STATEMENT OF RESPONSE

Coastal Quarter SHD 2 Planning Application

IE000468
Coastal Quarter SHD, Bray
F01
14 September 2022

LARGE CAR

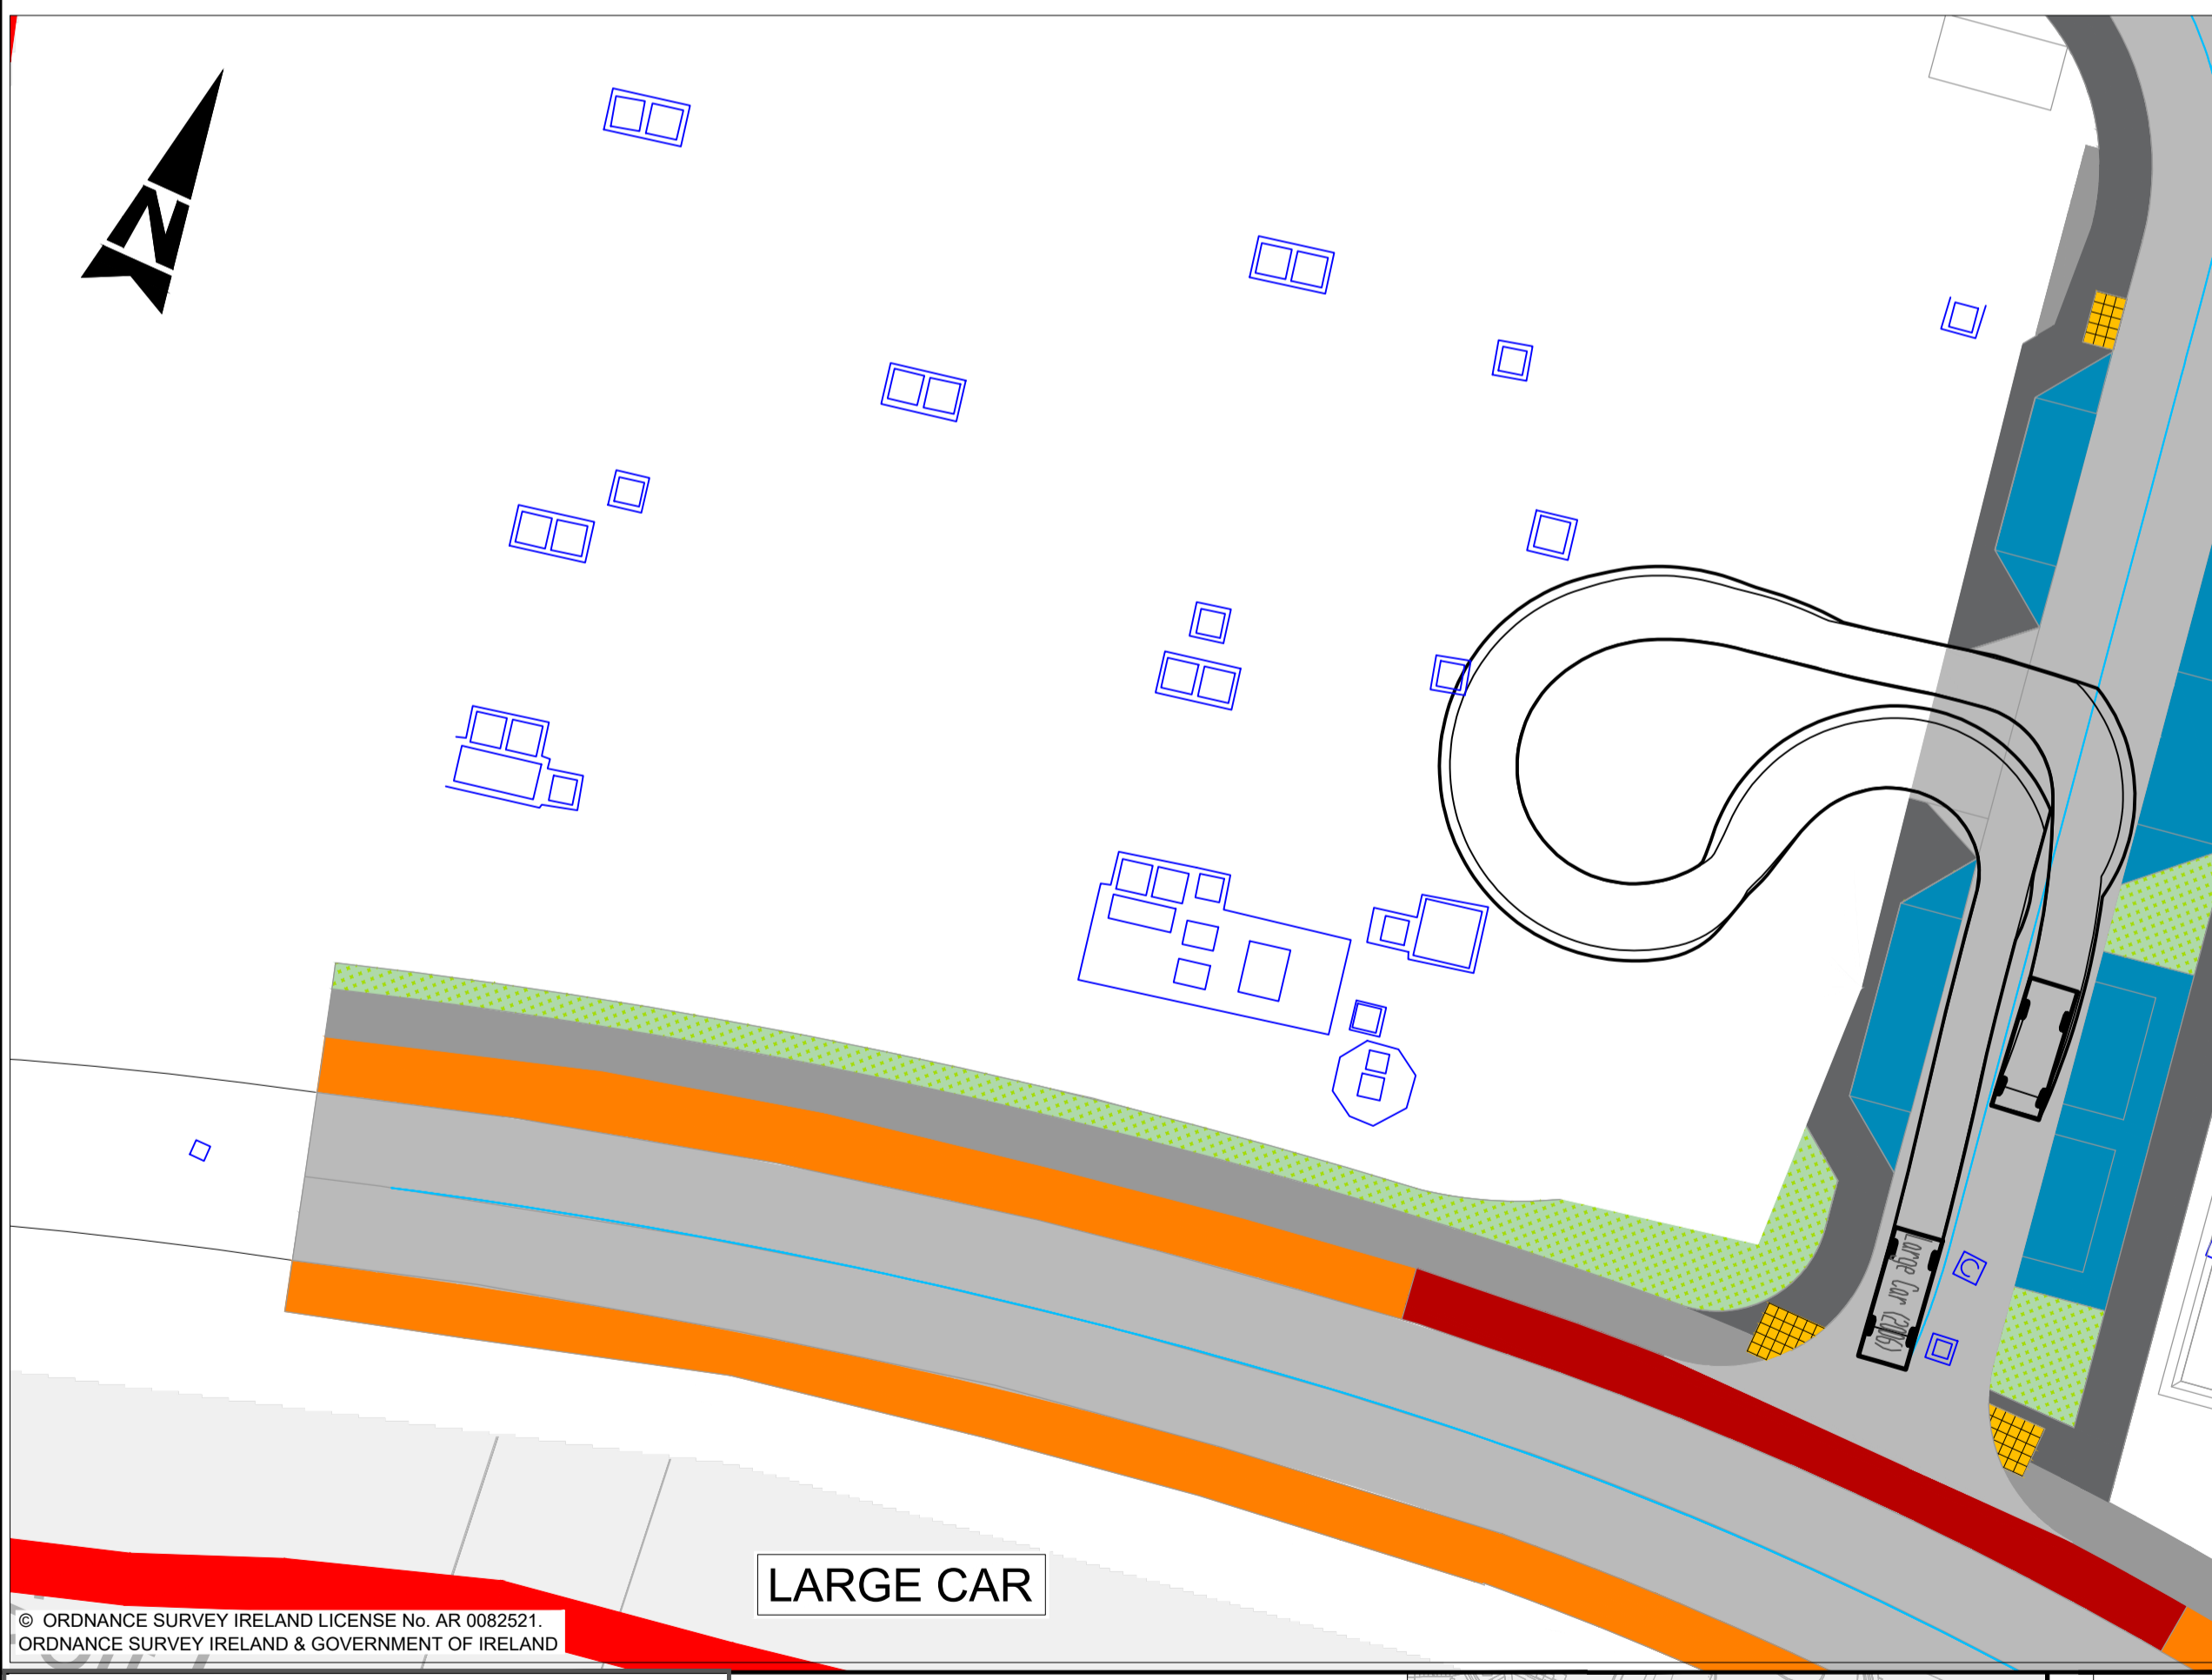
- *“The Applicant shall submit details which demonstrate the justification and purpose of the proposed overflow car park within the Orchard Area which contains 54 No. car parking spaces.”*

It is no longer proposed that car parking spaces be provided in the Orchard Area.
